**DELEGATED DECISION TO DETERMINE APPLICATIONS FOR  
CONSENT, AGREEMENT OR APPROVAL REQUIRED BY CONDITION**

Reference No:	<b>2024/44/92978/W</b>
Site Address:	Land adjacent to, 152, Somerset Road, Almondbury, Huddersfield, HD5 8HY
Description:	Discharge of details reserved by conditions 7 and 8 (materials), 10 (access) on permission 2024/91673 for variation condition 2 (plans) on previous permission 2023/91327 for erection of detached dwelling.
Recommending Officer:	Katie Chew

## Officer Report

**Proposal:** Discharge of details reserved by Conditions 7 & 8 (materials) 10 (access) of permission 2024/91673 for the variation of condition 2 (plans) on previous permission 2023/91327 for erection of detached dwelling.

Site Plan
1 : 200

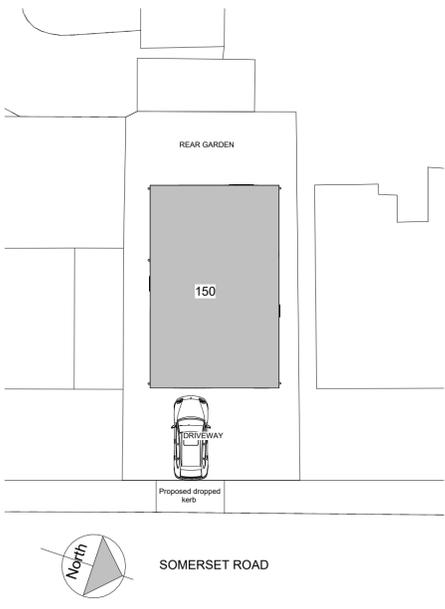
The applicants have sought to submit drawing no. 772-001-Rev H ‘Proposed Plans’, which shows the proposed site access with a disabled parking space marking upon the highway (which previously blocked this access) moved away from the front of the site. This view is further supported by a letter which has also been produced by Studio J Architects which confirms the above.

Given the above, the Council’s Highways team have confirmed they have no objection to the discharge of this condition on the basis of the submitted detail. Officers concur with this conclusion but note that the condition has an ongoing requirement in that the development cannot be brought into use until the approved access/scheme has been completed, and once finalised, retained as such thereafter.

The submitted information is considered to be acceptable to satisfy the requirements of Condition 10 and therefore Condition 10 is hereby approved. It is a requirement of this condition that the development is not be brought into use until it is completed in accordance with the approved scheme therefore this condition will remain in effect until all works comprised within the measures specified above have been carried out in full. Once completed, the measures are required to be retained thereafter. This condition therefore remains in perpetuity.
